S Harnett County - Application Tracking Individual Step Mai...

Application number 09 50022557  
 Application type CP NEW RESIDENTIAL (SFD)  
 Revision number  
 Path/Step/Seq/Agency A 10 00  
 Date submitted, resulted 81409  
 Status code  
 Reviewed by  
 Revised est cpl date 81309  
 Copies of plans

PLOT PLAN
 OF
LOT 7
JONATHAN RIDGE
HARNETT COUNTY
 FOR
SCOTT LEE HOMES

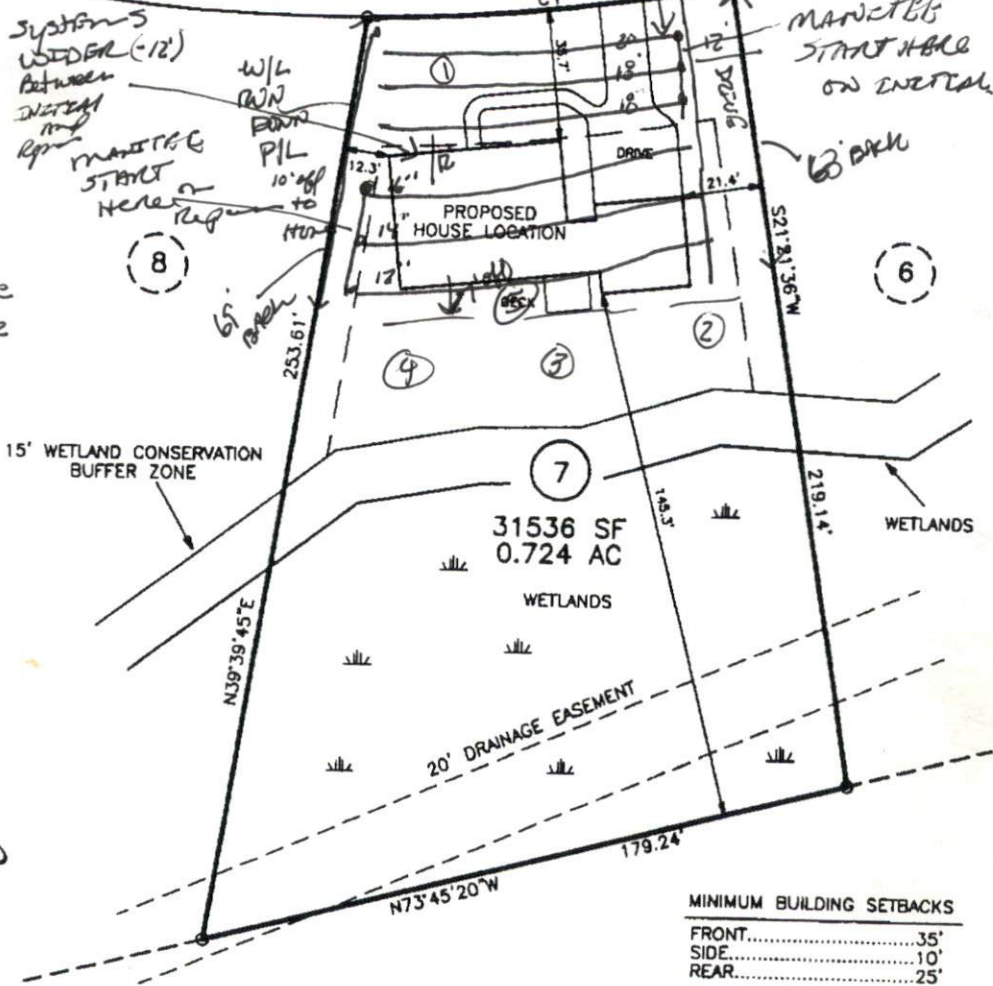
Seq	Comments	Prt	Date
1.000	RE-MARK BUFFER ZONES PER MAP. T/S: 08/14/2009 11:19 AM SSTEWARD -----		81409
2.000	T/S: 09/04/2009 11:12 AM SSTEWARD ----- CALL 893-7547 TO SCHEDULE A MEETING IN ENVH WITH JAMES MANHART TO SCALE OUT AVAILABLE SPACE FOR HOUSE PLACEMENT.		90409
3.000	ON HOLD PER BUILDER'S DECISION.		92409
